WEST SUSSEX COUNTY COUNCIL CONSULTATION

TO:	Arun District Council FAO: Amy Myer
FROM:	WSCC - Highways Authority
DATE:	24 February 2021
LOCATION:	Butlins Upper Bognor Road Bognor Regis PO21 1JJ
SUBJECT:	BR/307/20/PL New reception kiosk and alterations to car park layout. This application is in CIL Zone 4 zero rated as other development- Revised information received
DATE OF SITE VISIT:	Site known to Officer
RECOMMENDATION:	No Objection
<u>S106</u> CONTRIBUTION TOTAL:

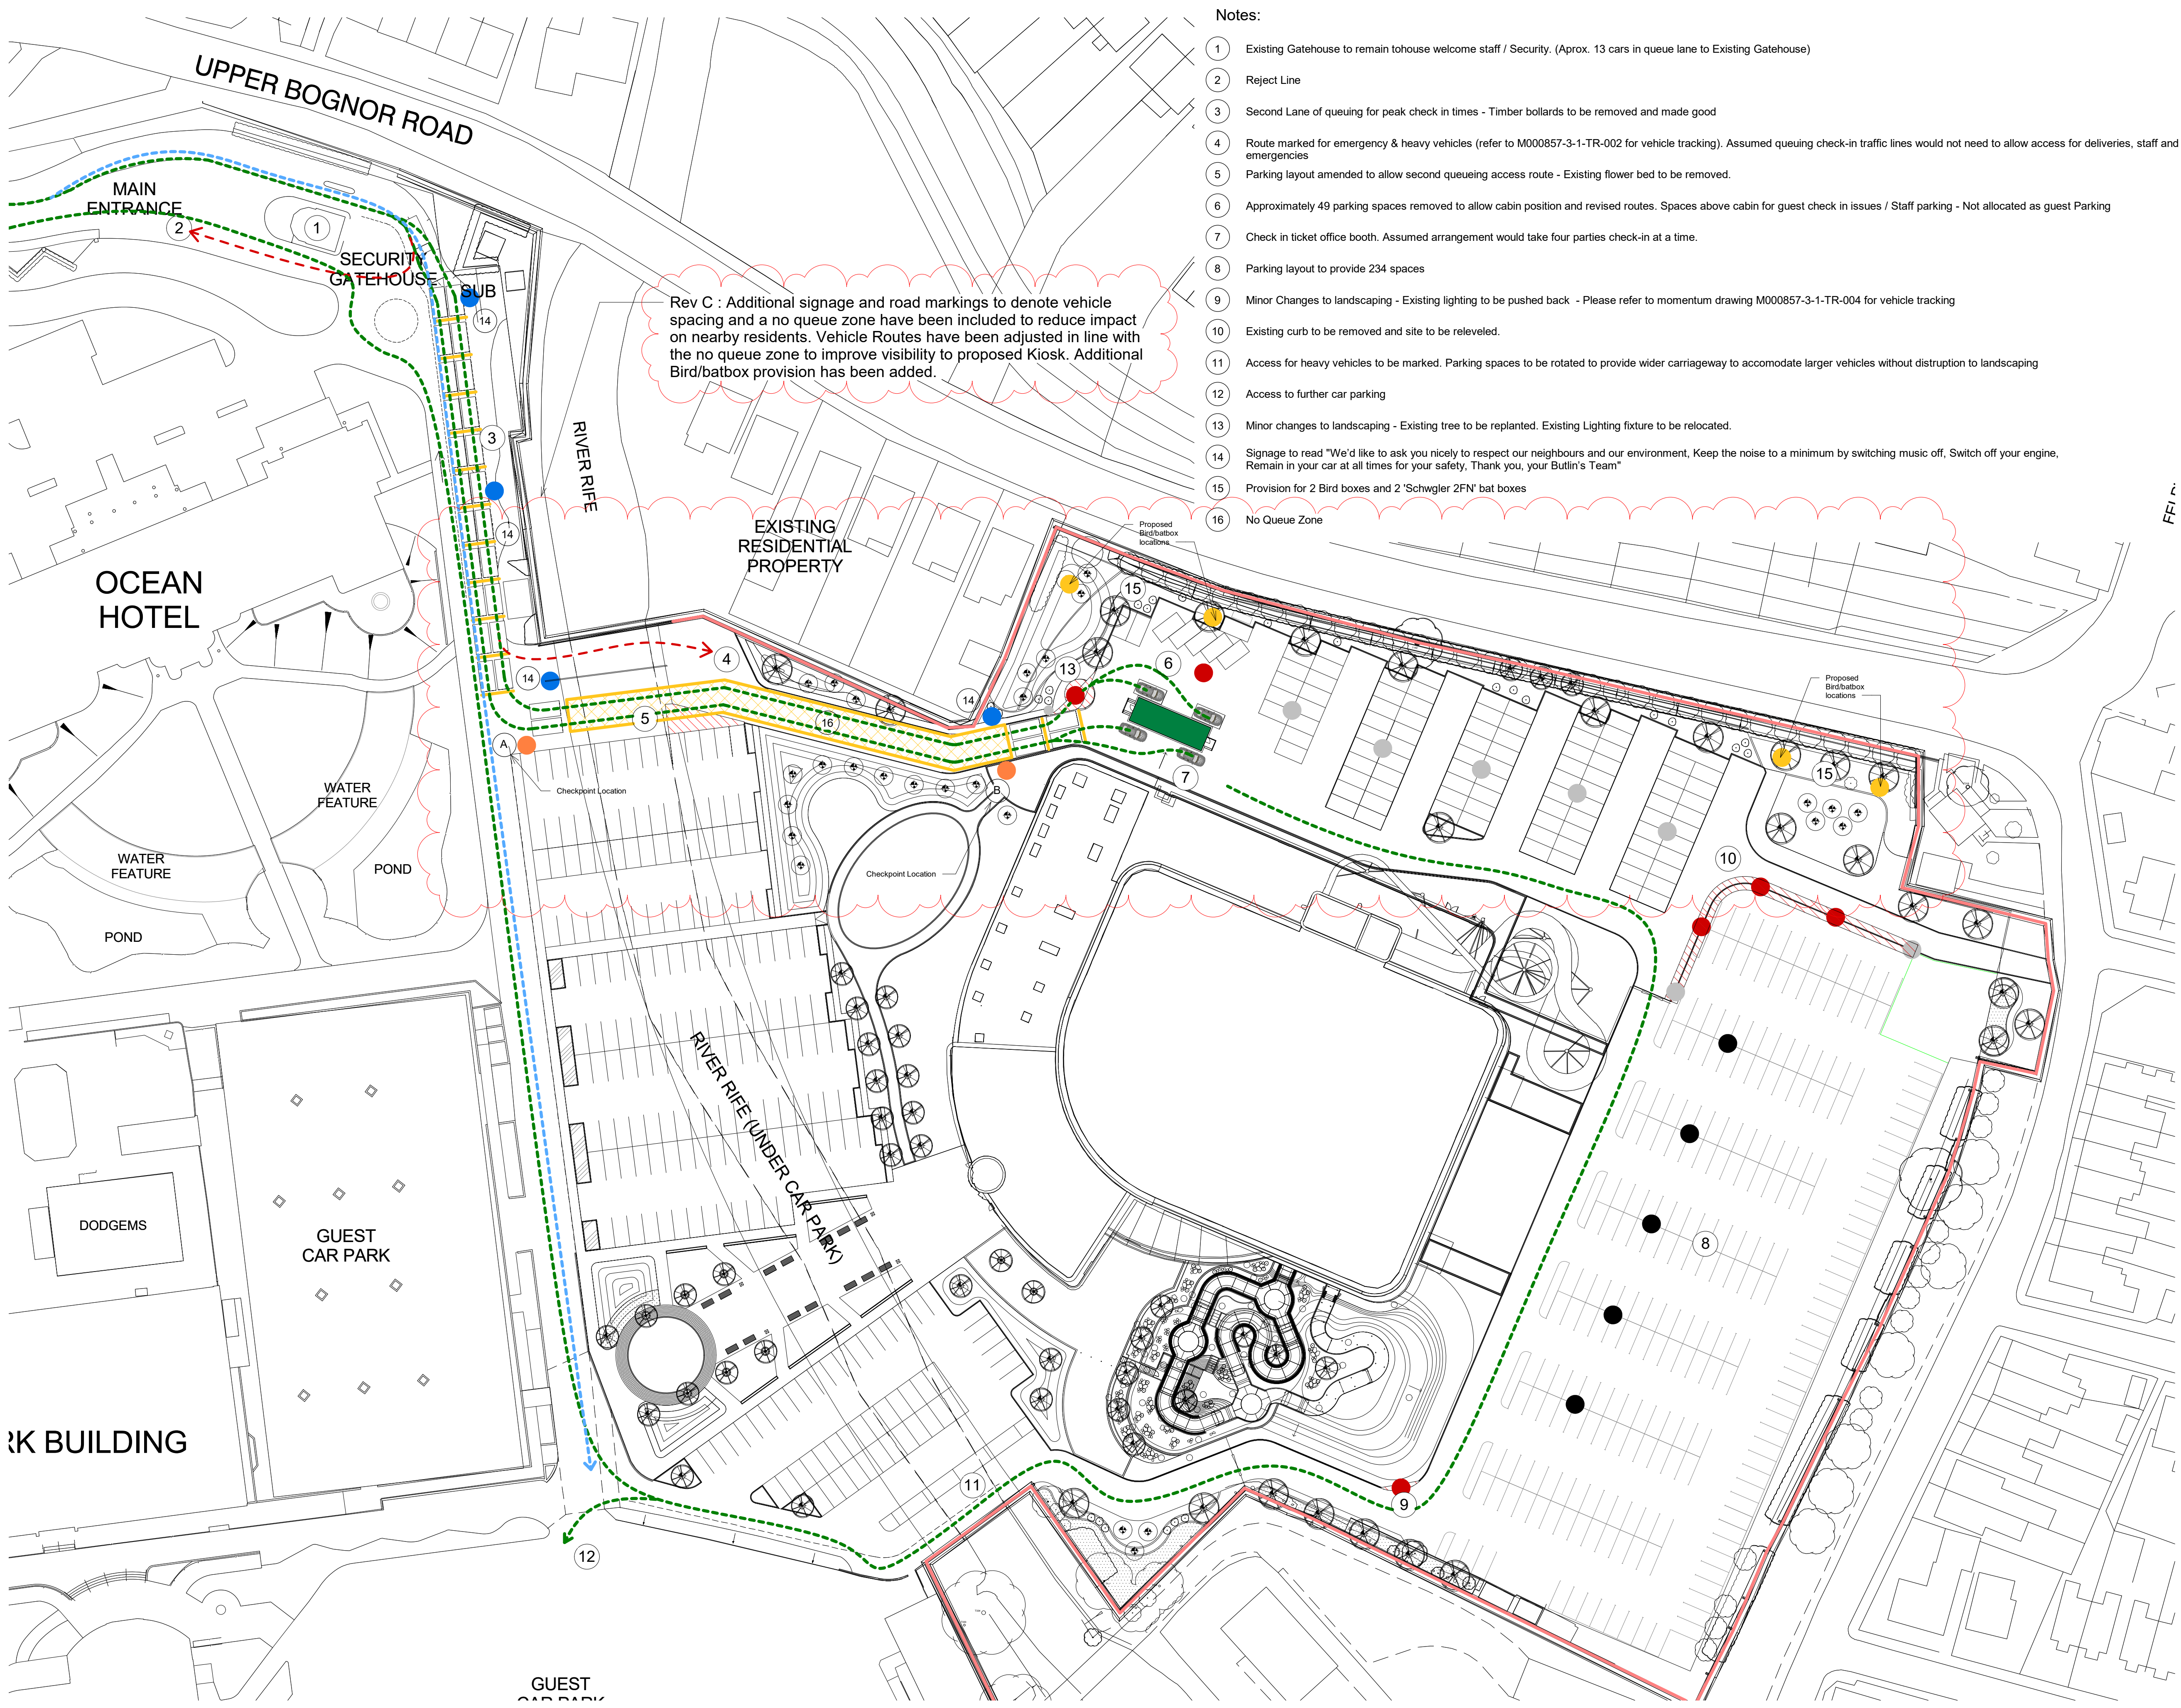
A revised proposed site plan has been submitted, drawing no: 2014 WOO-MPN-BOG-DR-A-0010 Rev B. This now shows that vehicles will not queue behind the adjacent residential properties that back onto the site. Two lanes will be provided for the rest of the access road to help alleviate queuing traffic backing up on the roundabout at the site entrance from the highway.
